Biodiversity Offset Report - Modification 1 Response to Submissions

Prepared for Snowy Hydro Limited
October 2019

J17188 RP1

**Figure 2-19: Road Upgrades – Boulder Streams – Lower Lobs Hole Ravine Road – Cross Section**

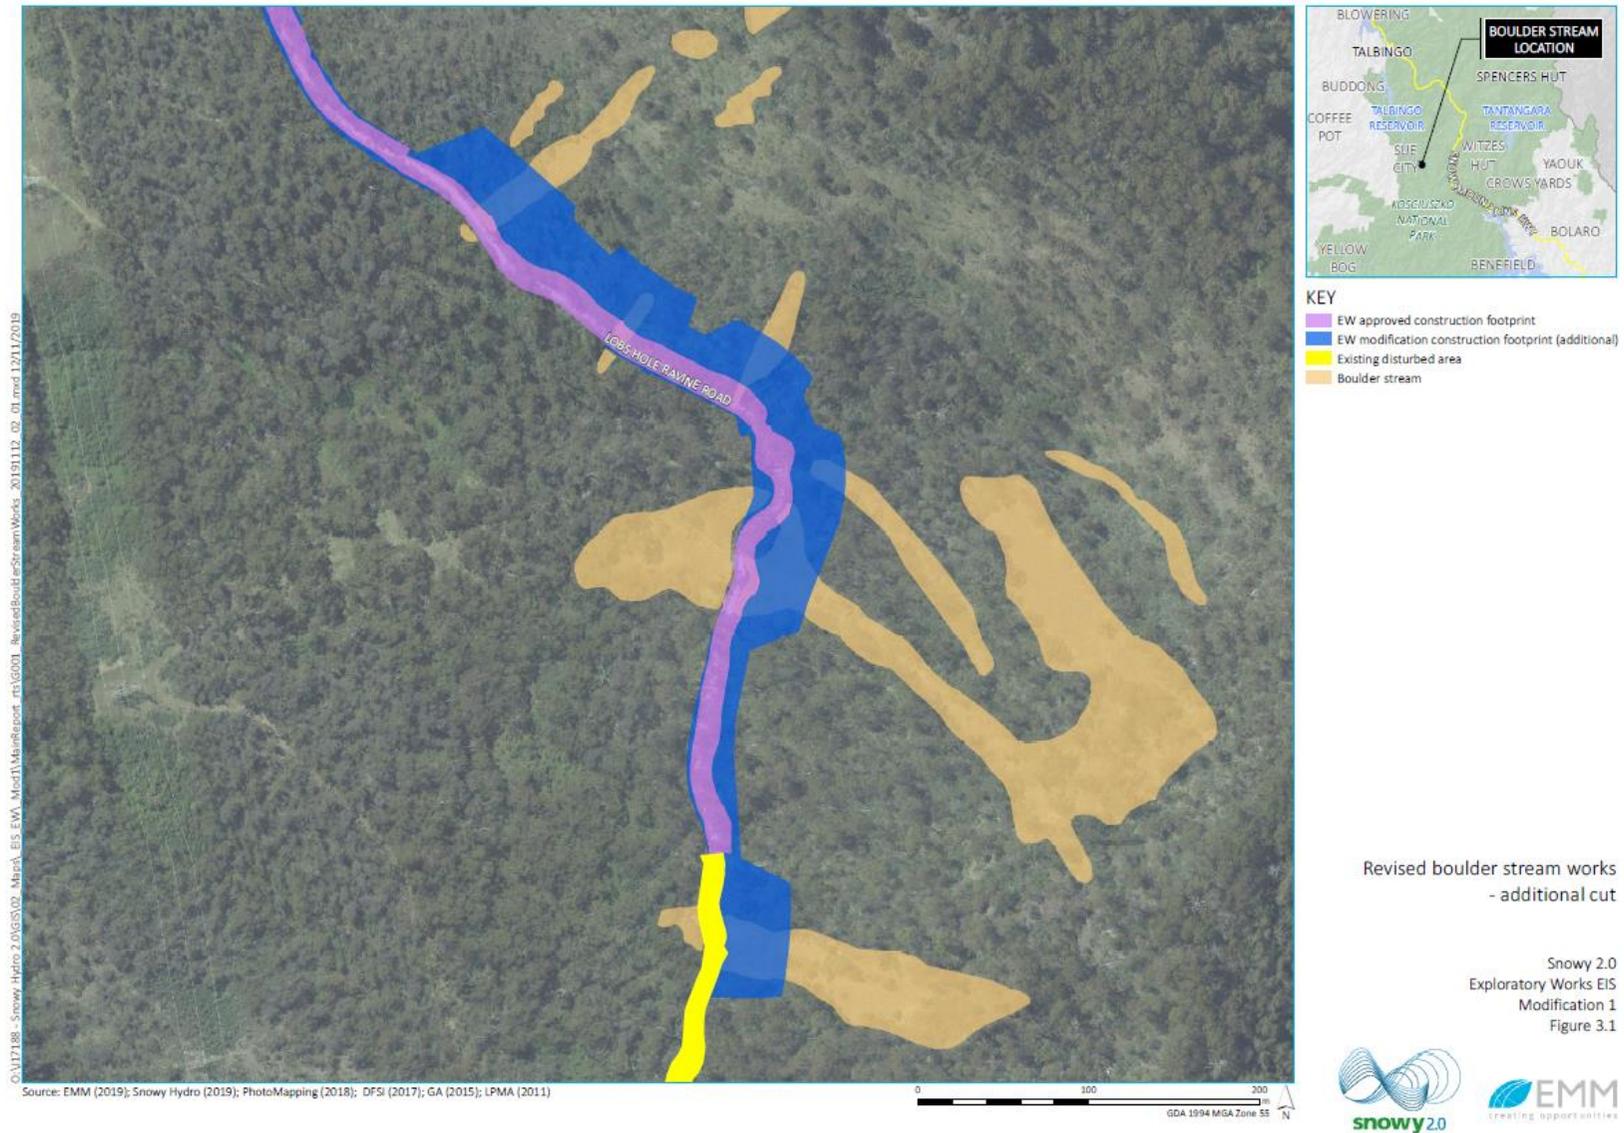
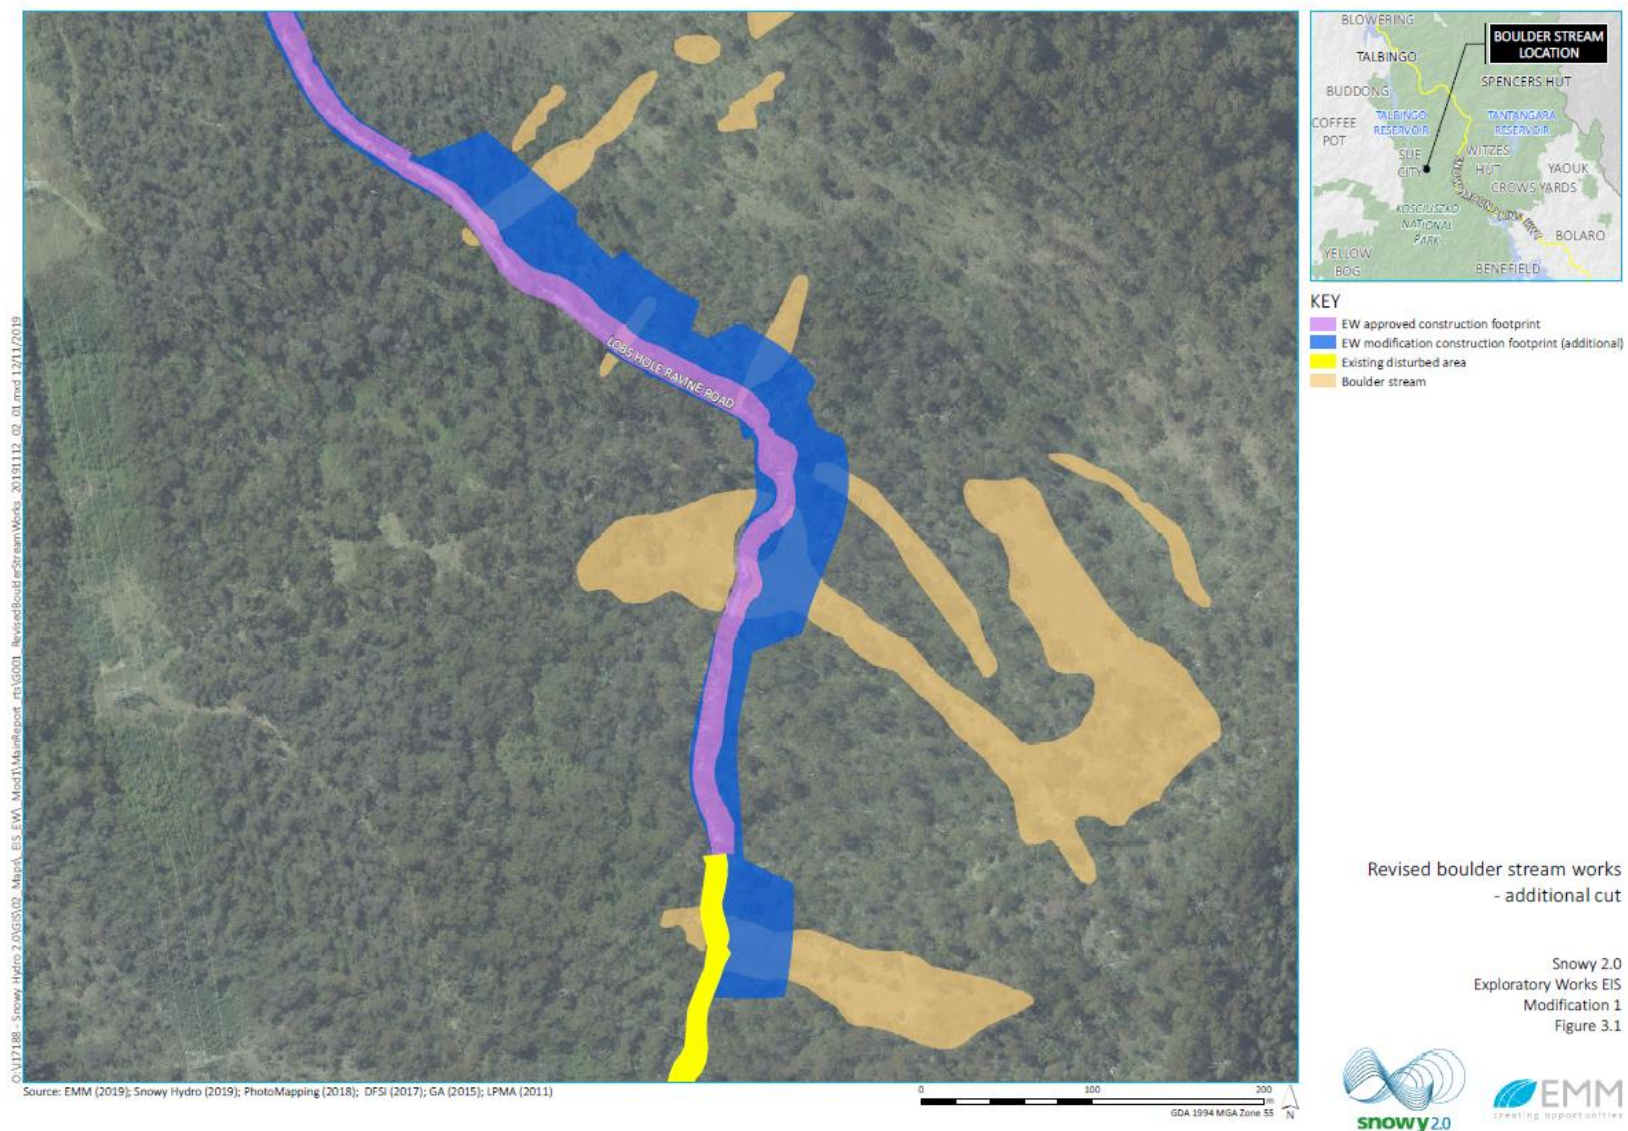
Submission	Response
Biodiversity BDC have reviewed the BDAR to support the modification. The credit calculation has been adjusted to account for areas where the clearing has been reduced. However, the calculation is based on a 4m wide road width. Does not appear to account for any cut and fill required on steep slopes. (See Key Issue 1). <i>Recommended action:</i> The road widths and laydown areas in steep areas are to be reconsidered and if it is necessary to widen the roads in sections, then the offsetting requirements are to be recalculated.	The access tracks required to these boreholes were shown in the Modification 1 Assessment Report figures and assessed in the impact assessment including biodiversity offset calculations. Access tracks to BH7201 and BH7212 are 12m wide and are expected to accommodate cut and fill requirements through steep slopes in these areas. No reconsideration is required.
